## Comments on Change Request 2

### Change 2. Airport.

Title: Illustrative Masterplan
Figure 5.3: Cable Corridor Plan Overview - Area between the Northern and Central Sites on land to the east of Woodstock and in the vicinity of the Bladon roundabout on the A44

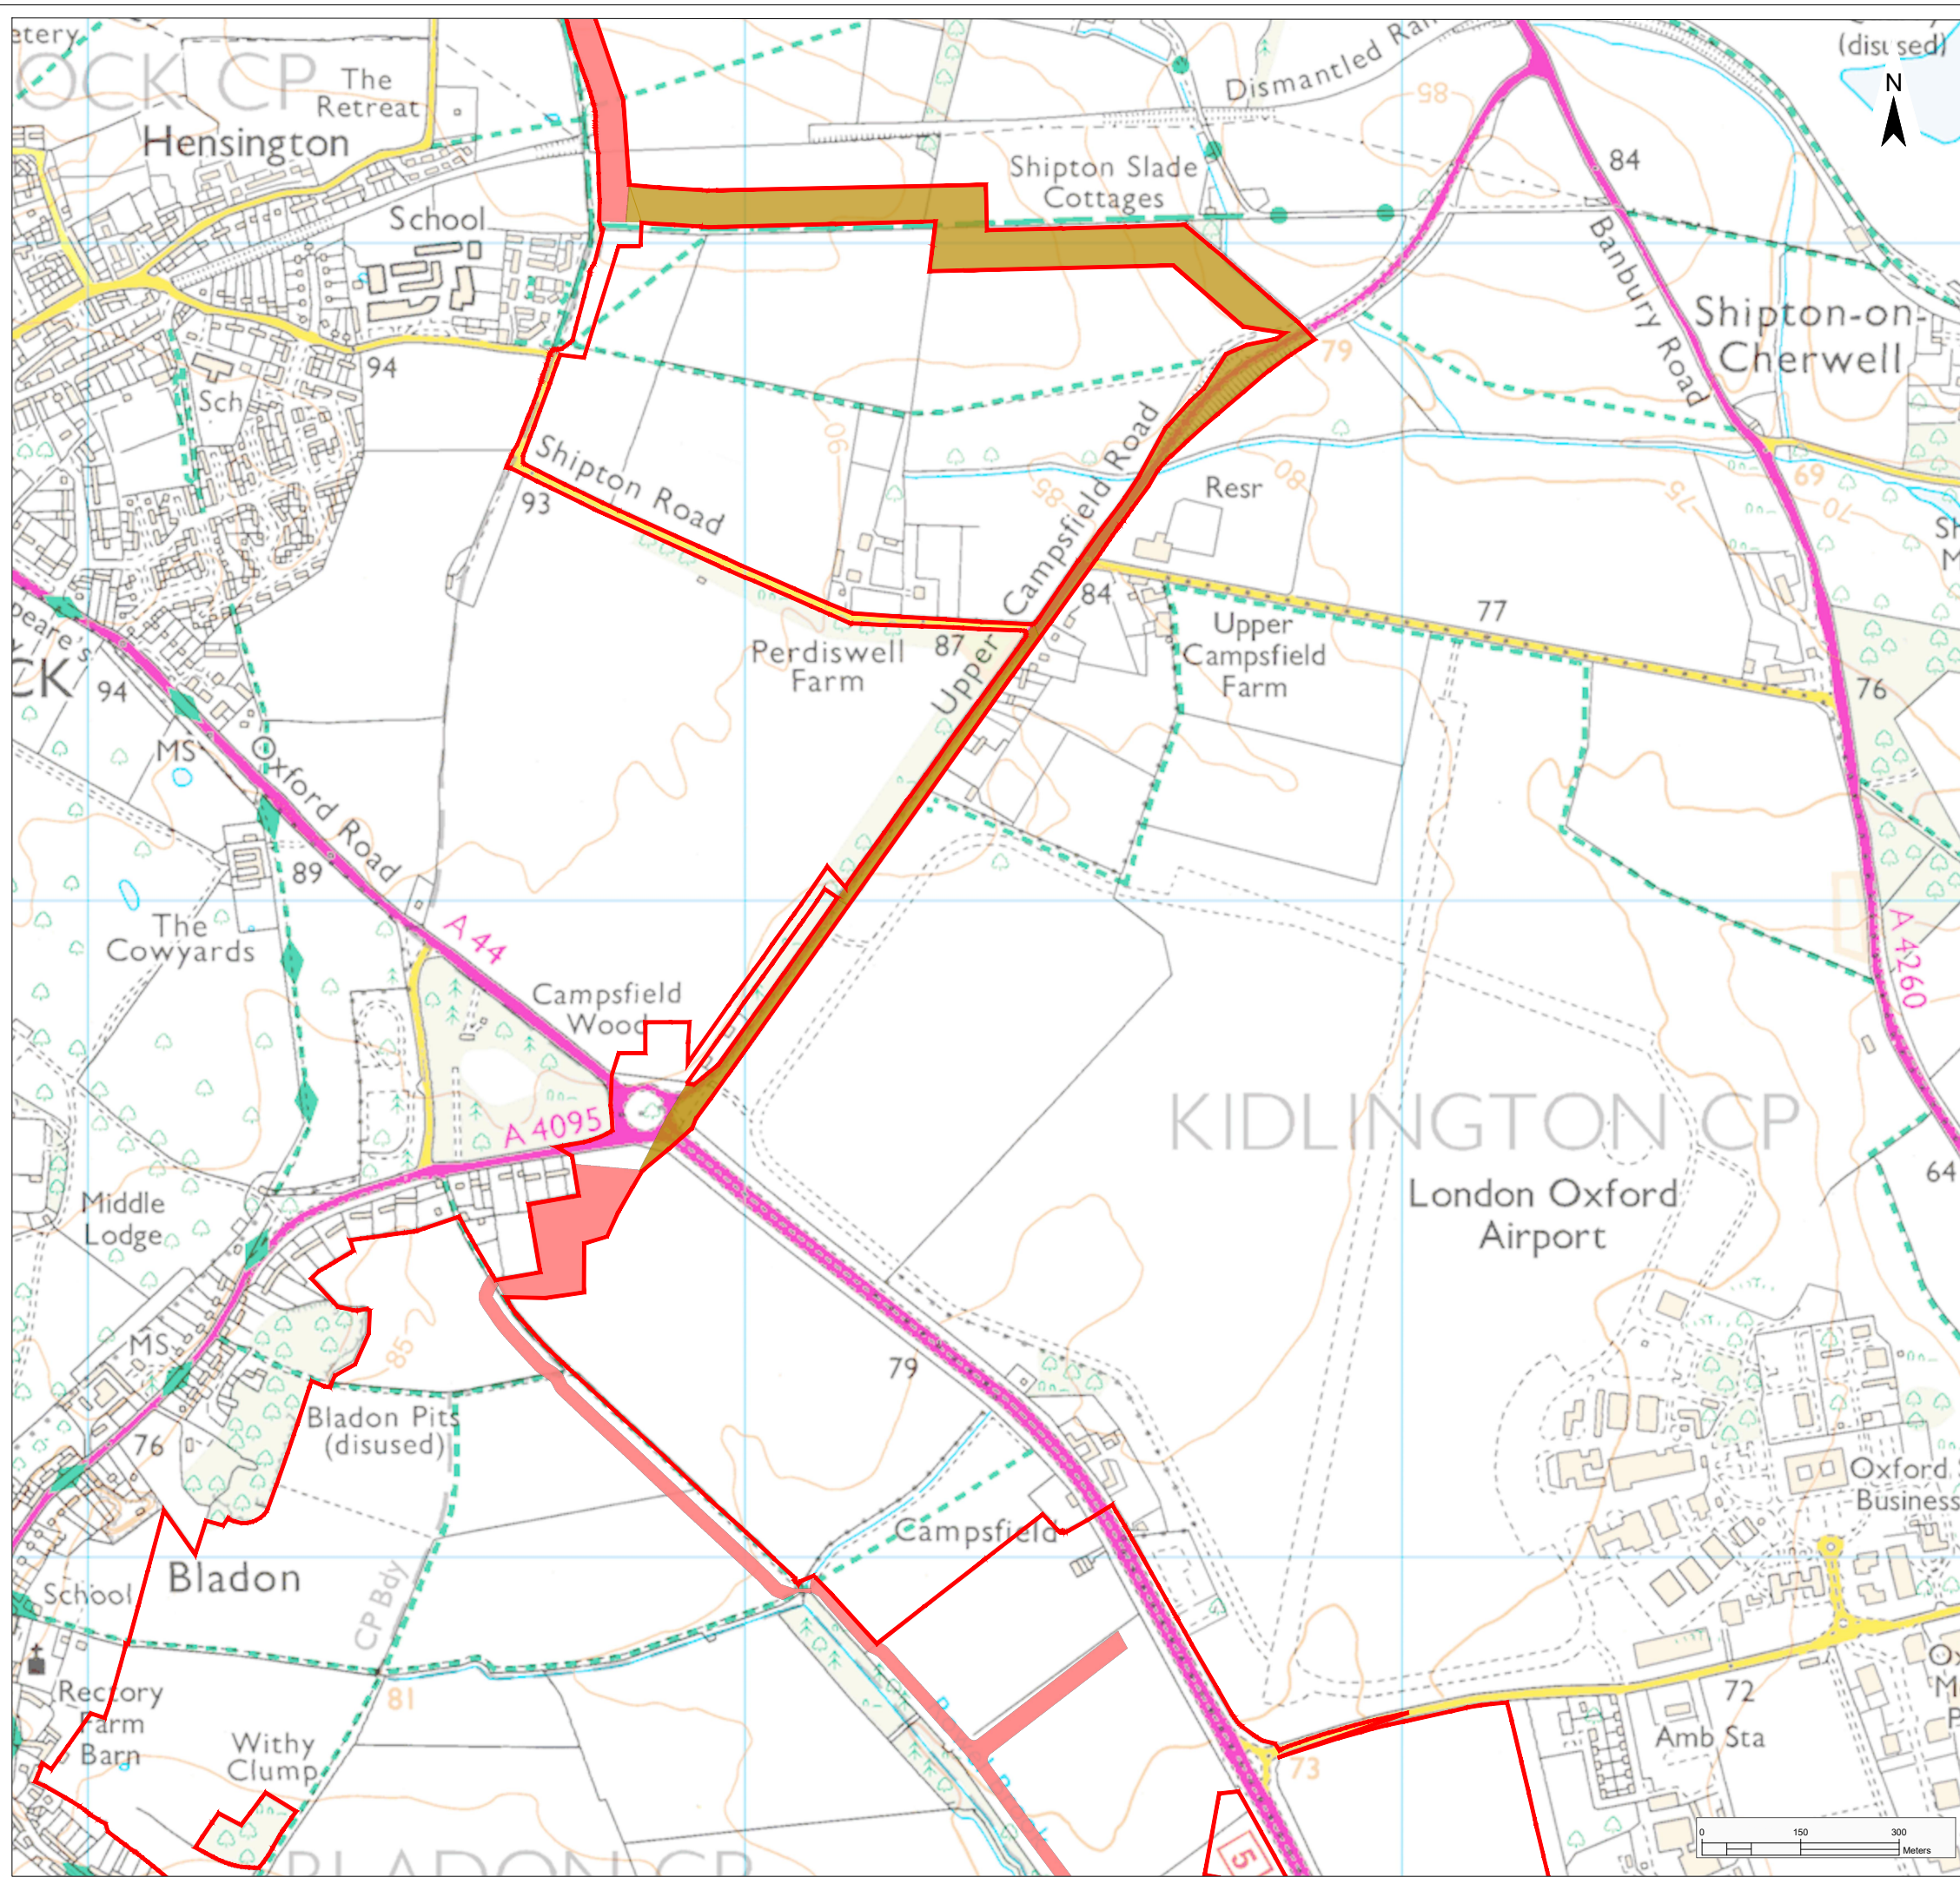
It makes no sense to leave a thin strip of panels in the North West corner of field 2.15 adjacent to Bladon Heath which is an ancient woodland with a rich habitat for all manner of wildlife including barn owls.

The edge of this woodland is already threatened by the proposed cable trenching around its south eastern edge. I presume that, once buried, the cable route will not be fenced and it can surely not be cost effective to put fencing all the way around the remaining narrow strip of panels. This fencing plus hedging on the eastern edge of the panels to screen them from a very well used bridleway would overwhelm the area for walkers and restrict the wildlife corridor between Bladon Heath and Begbroke Wood.

Please remove this strip of panels with the rest of those already agreed and adjust the Order Limits Boundary
